Application for a Non-Material Amendment Following a Grant of Planning Permission

Construction of a new dwelling and associated works

PA20/09048

STATUS: Planning
DRAWING NO.: 2804-3-021
REVISION: G

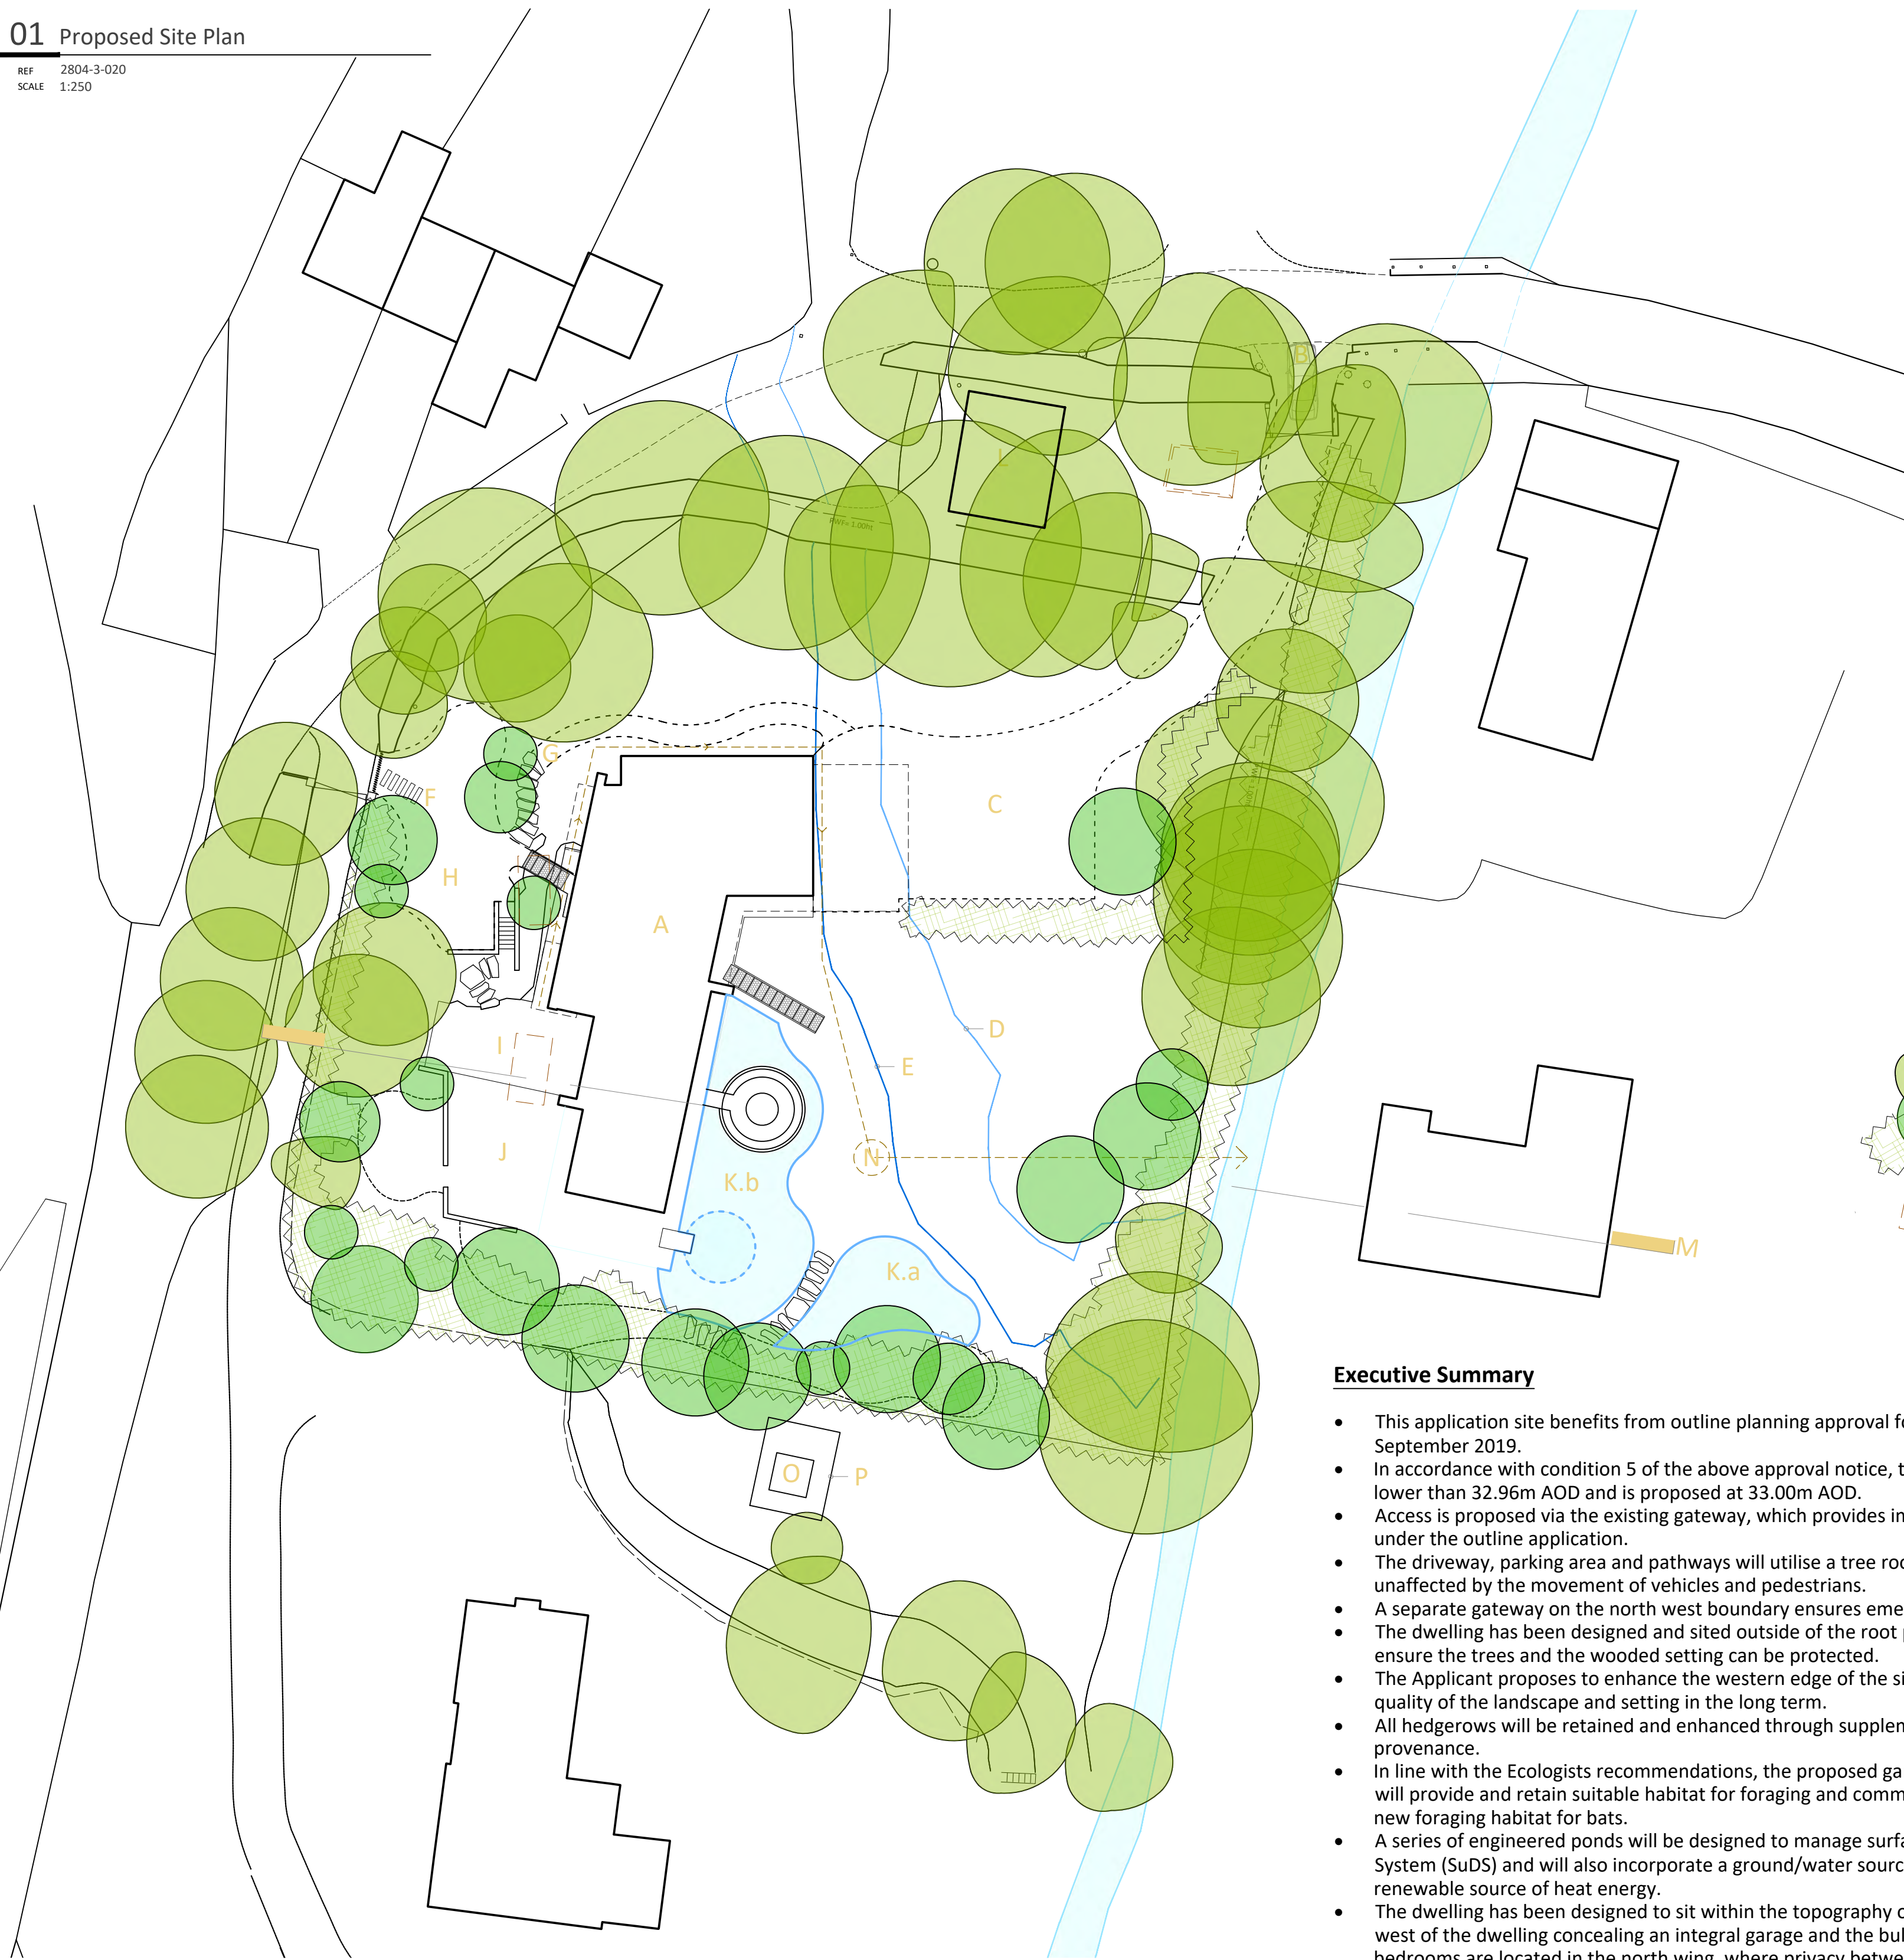
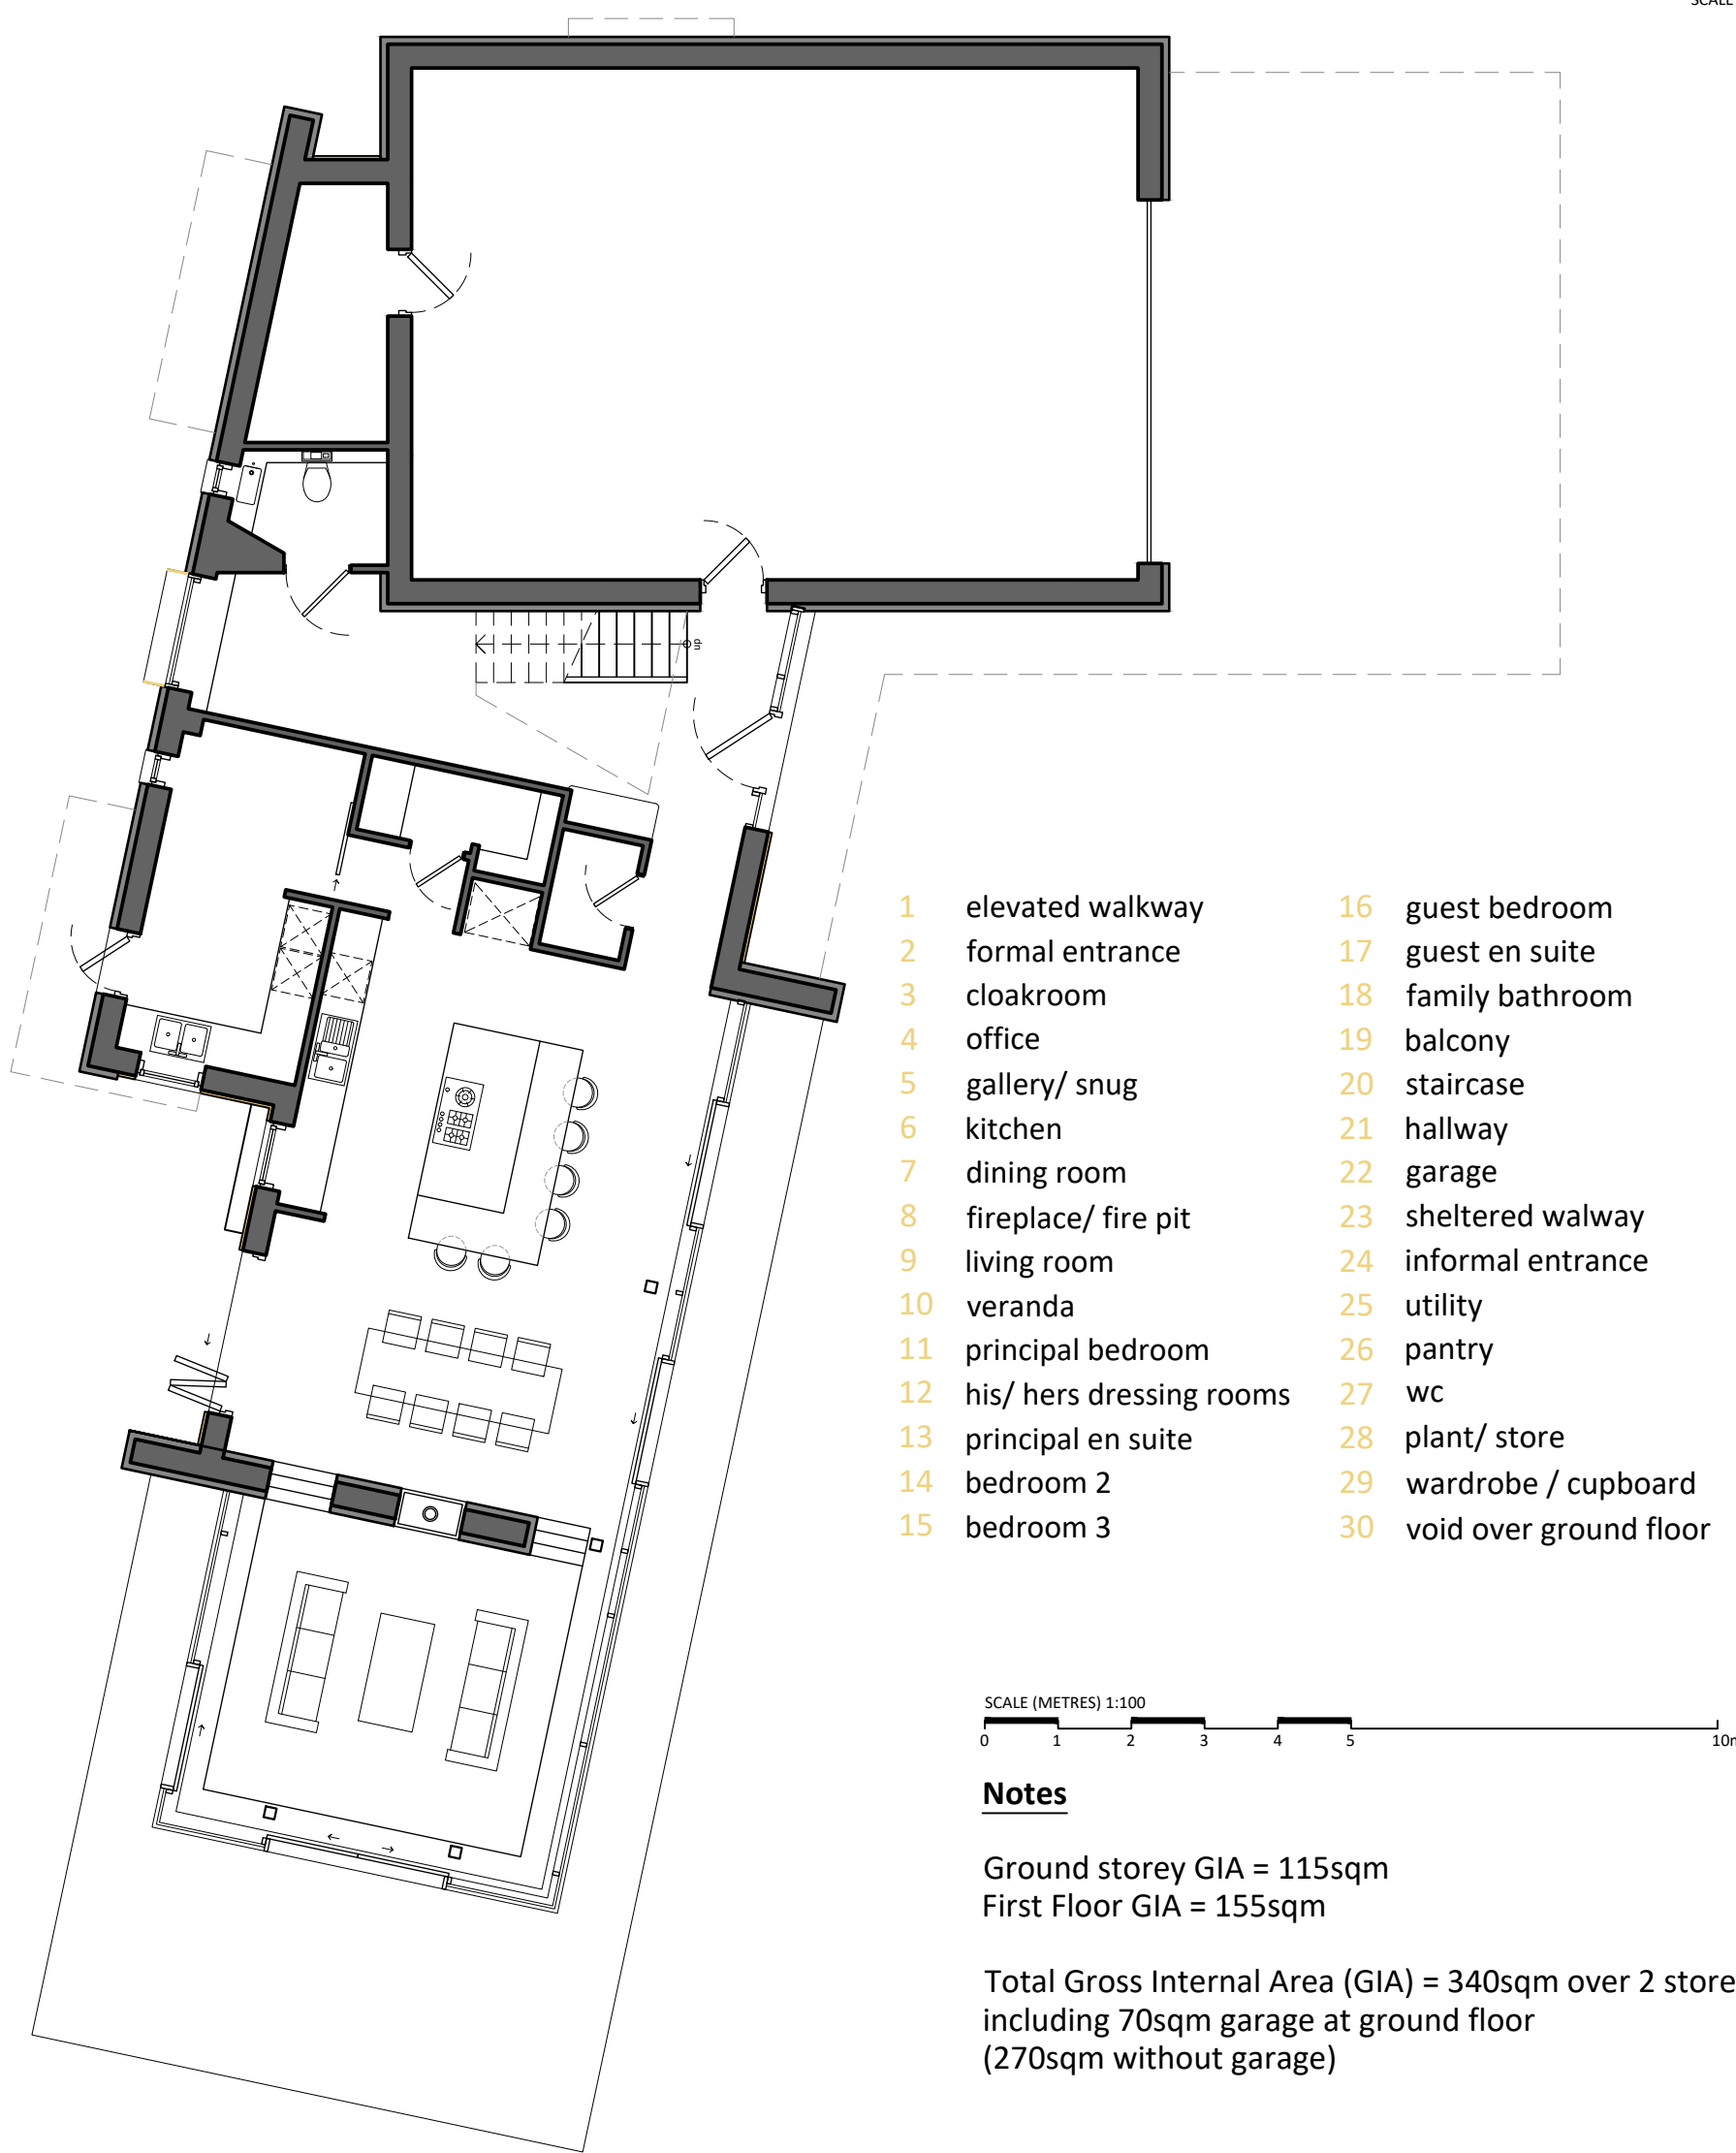
Revisions to fenestration focusing on reduction in the width of the full height glazed opening into the landing at first floor level on the east elevation and installation of a narrow glazed panel at the opposing end of the landing on this elevation.

The changes to the fenestration are to provide additional light to the core internal circulation spaces of the new dwelling whilst at the same time maintaining the distinct character of the contemporary design and the overall proportion of glazing.
